A & G Residential
916 Arsenal Ave
Suite B
Fayetteville, NC 28305

RE: Daily Field Report for 03/09/2023
 Lot 45 Liberty Meadows (CMT) Cameron, NC
 Building & Earth Project No : RD230064

FO-1 : Field Observations made on this date.

- Foundation Inspection- Crawl Space

STEM WALL
FOUNDATION DETAILS

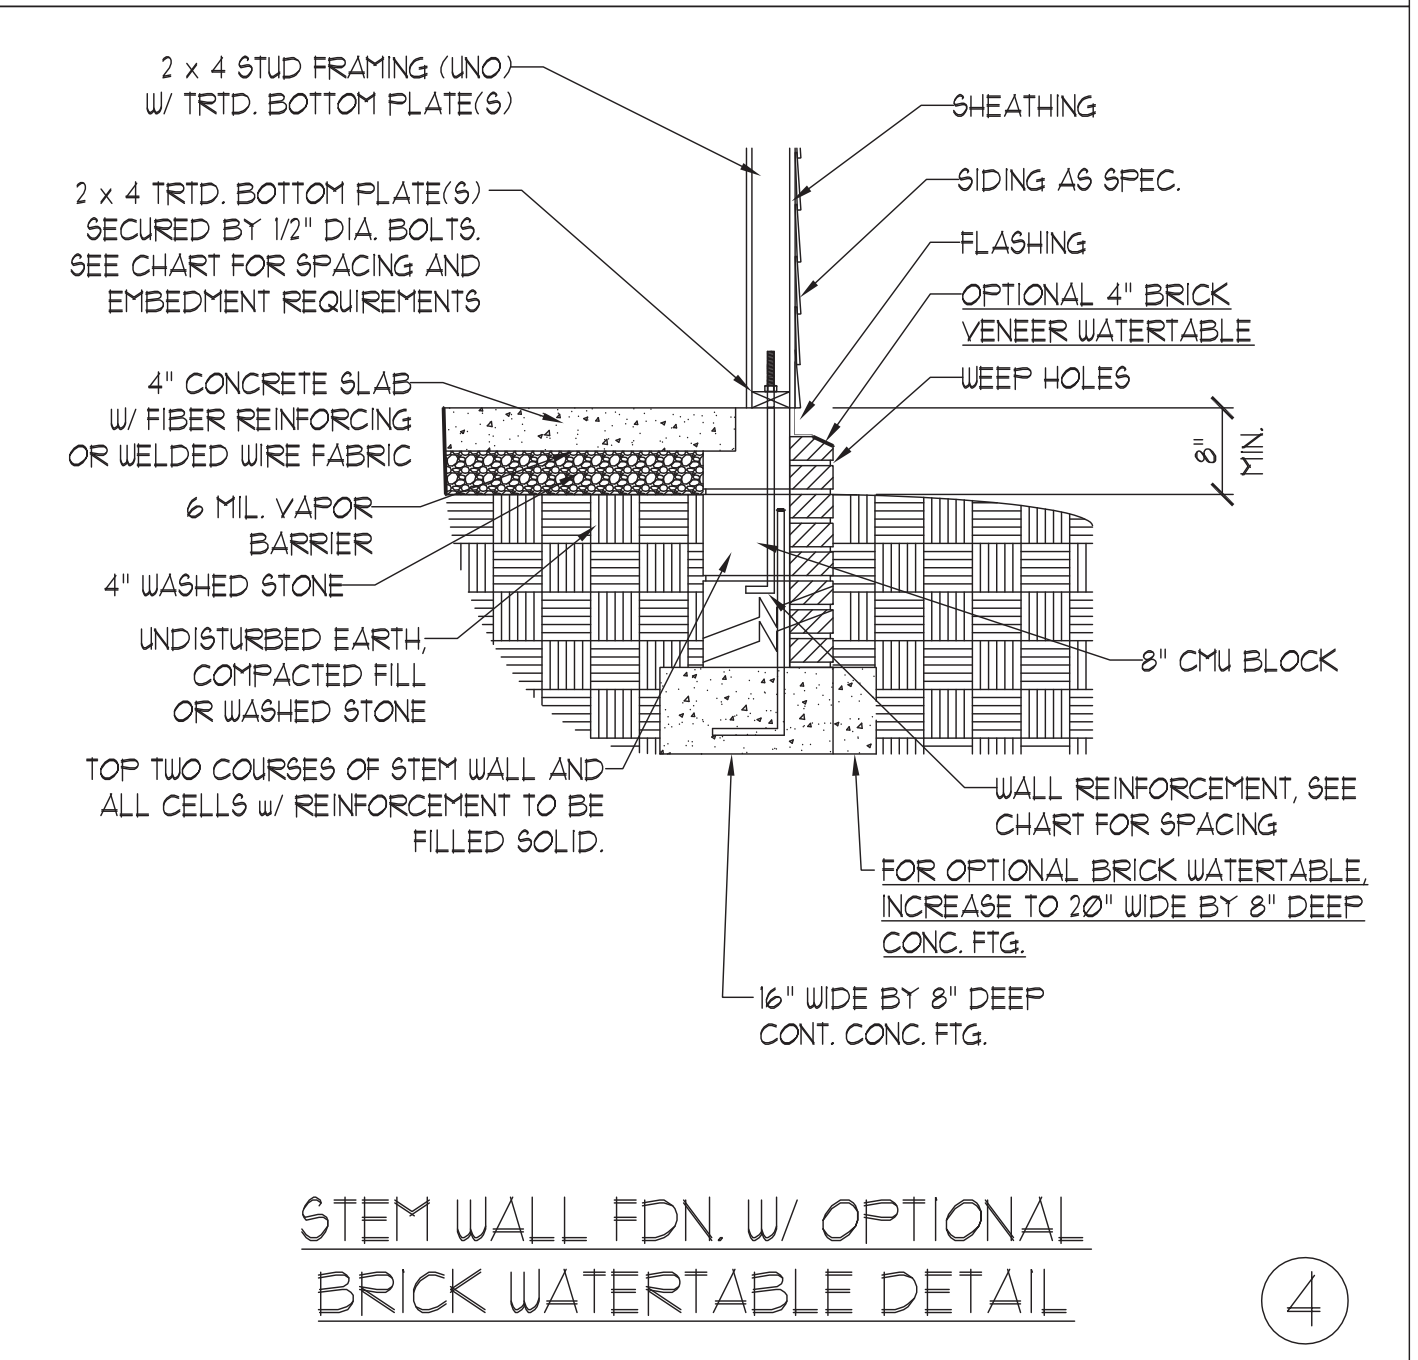
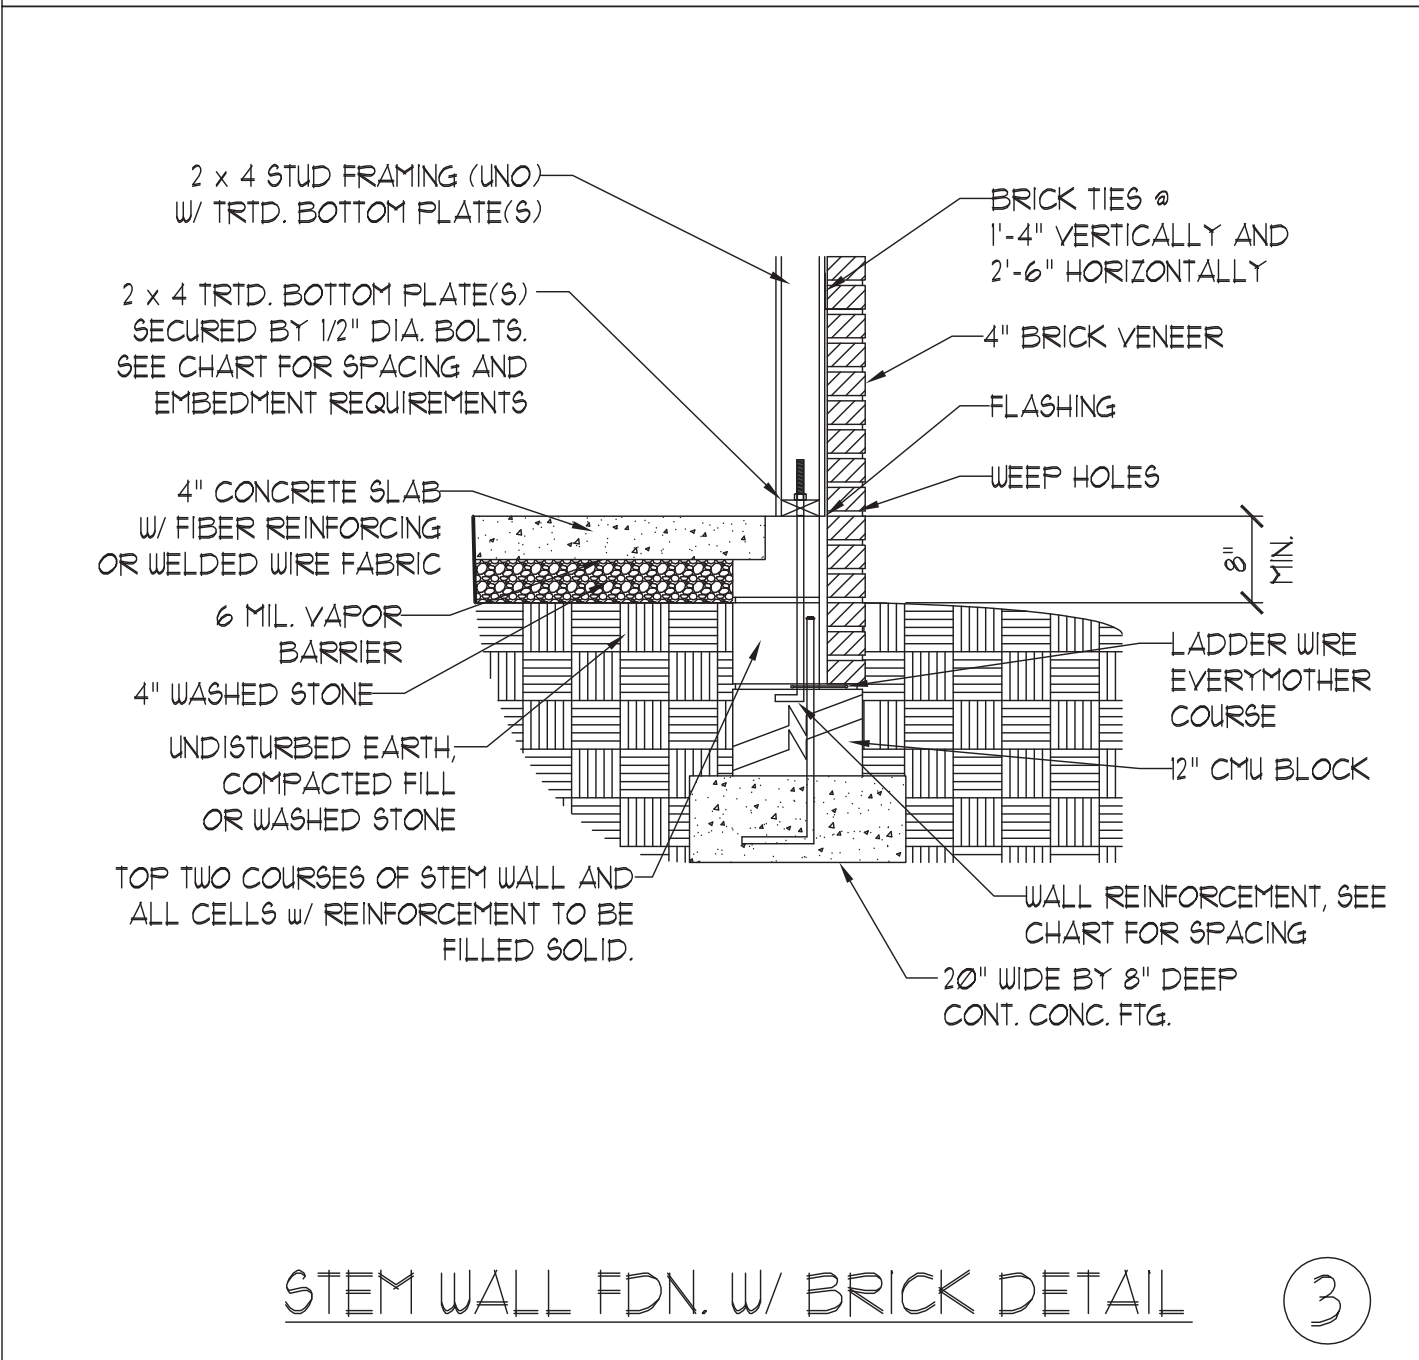
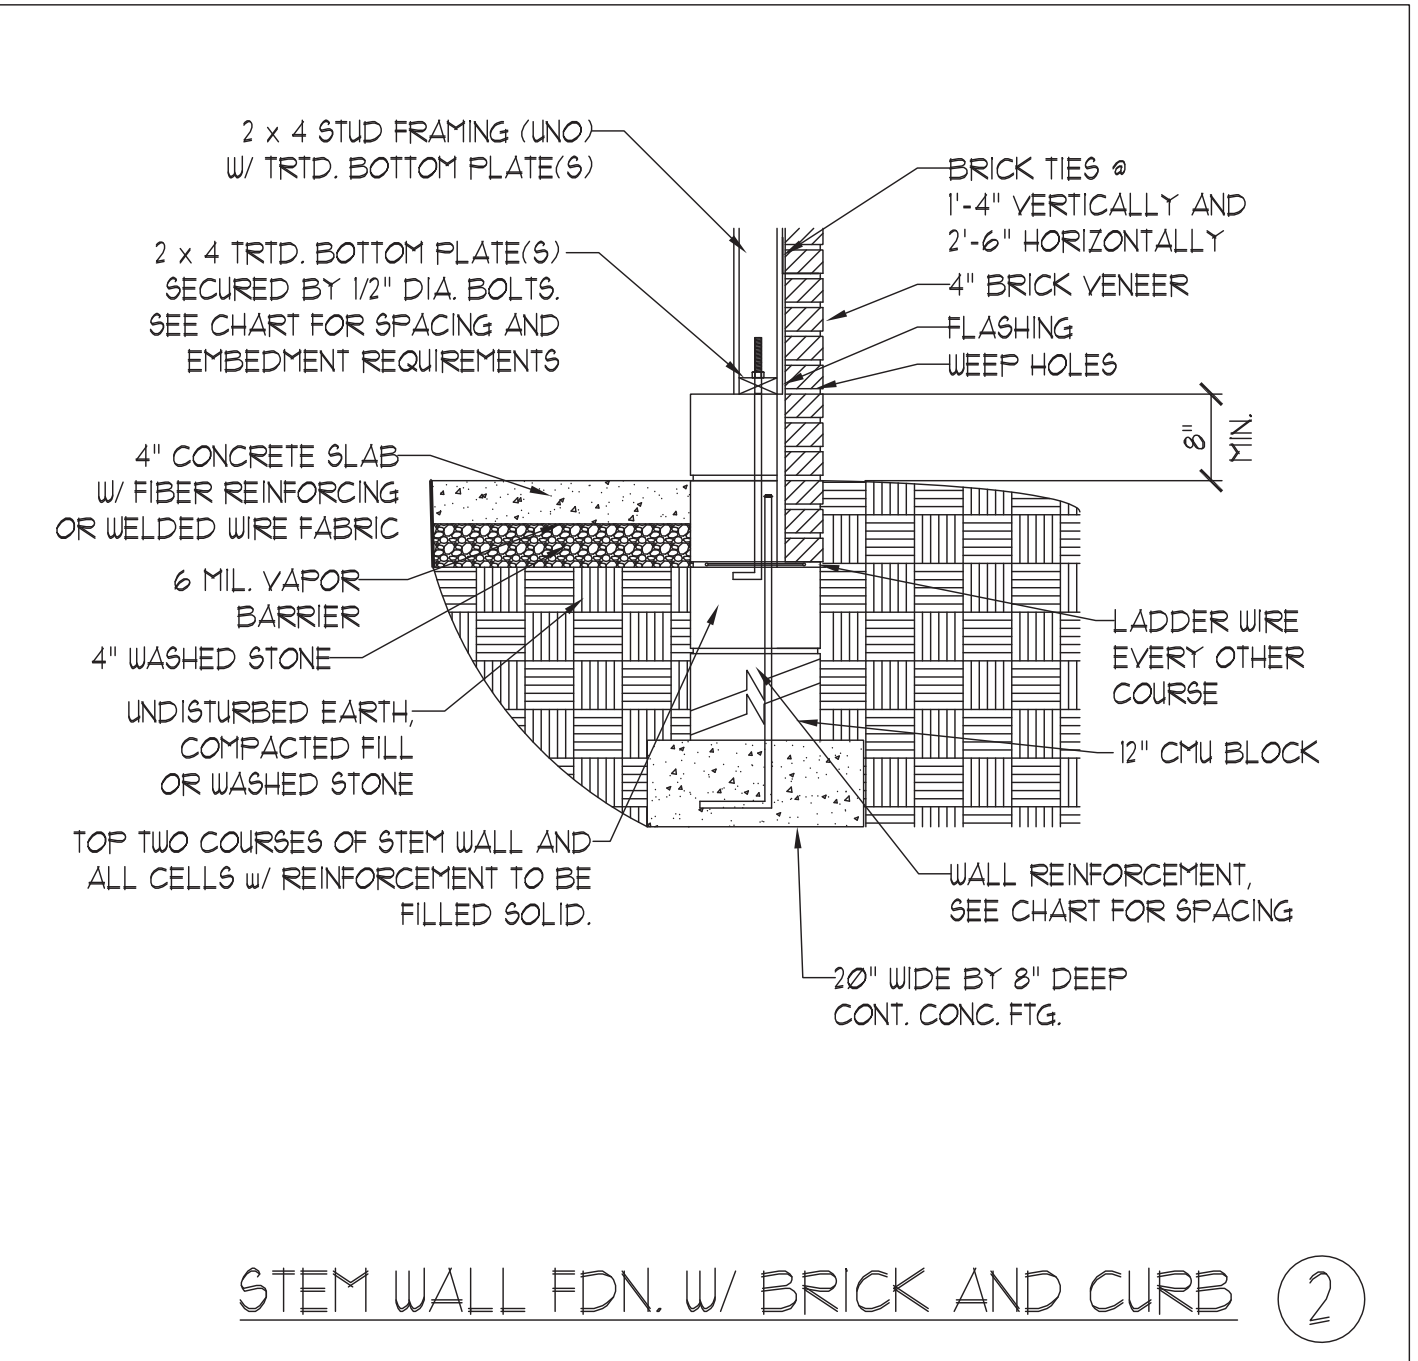
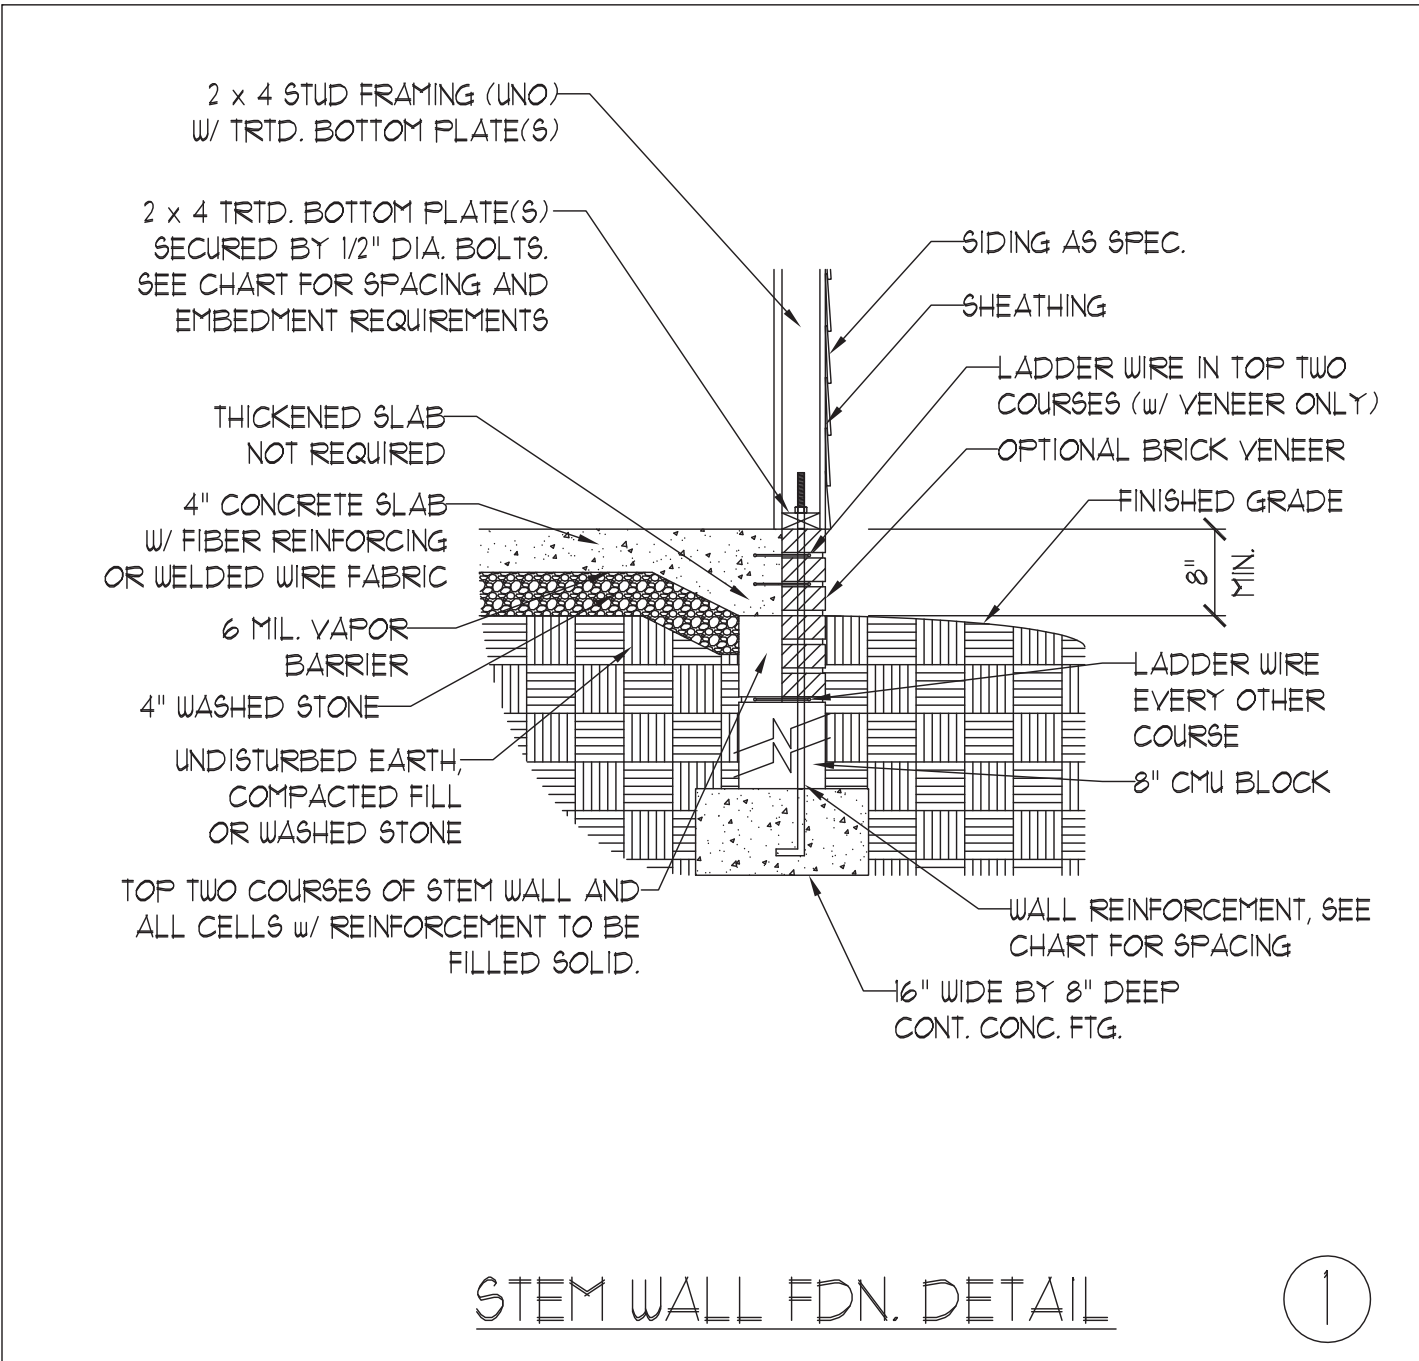
Comment 1 : Based on our testing results, we recommend undercutting the footings an additional 2 feet below bottom of footings. Install a permanent french drain from the lowest corner that daylight below the undercut depth. Backfill with washed NCDOT #57 stone wrapped in filter fabric.

Our evaluation included hand rod probing and advancing hand auger with Dynamic Cone Penetrometer (DCP) testing. Based upon our hand rod probing, the soils are loose to a depth of 30 inches. To confirm these results, hand auger borings were advanced at 4 locations across the building envelope. At 12-inch increments in the hand auger boring, to a depth of 3 feet, Dynamic Cone Penetrometer (DCP) Testing was performed in accordance with ASTM STP-399. The following data was retrieved from this testing:
